LYMINSTER & CROSSBUSH
PARISH COUNCIL

Planning Application LY/19/11

SITE PLAN — AS PROPOSED
1:200 @ A1

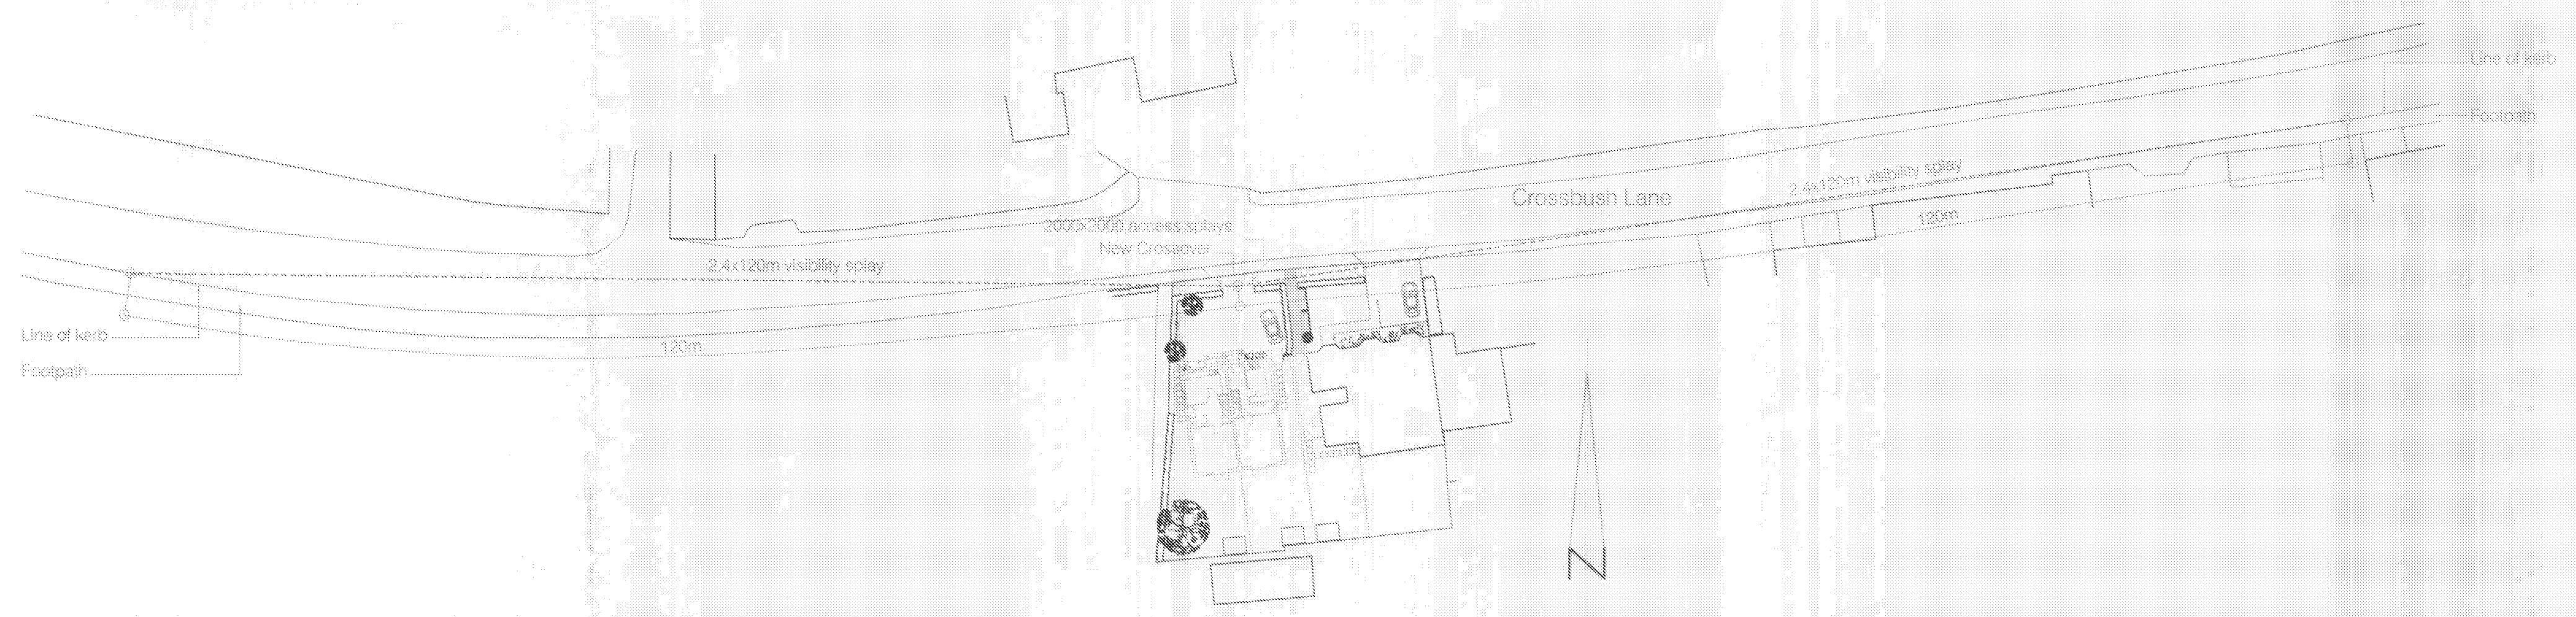
The Council would however like it recorded of their concerns re the site plan showing virtually all of the front part of the plot as off road parking. We would like this adhered to as parking and not half of it laid down to garden thus forcing more on-road parking which is already a problem at Crossbush.
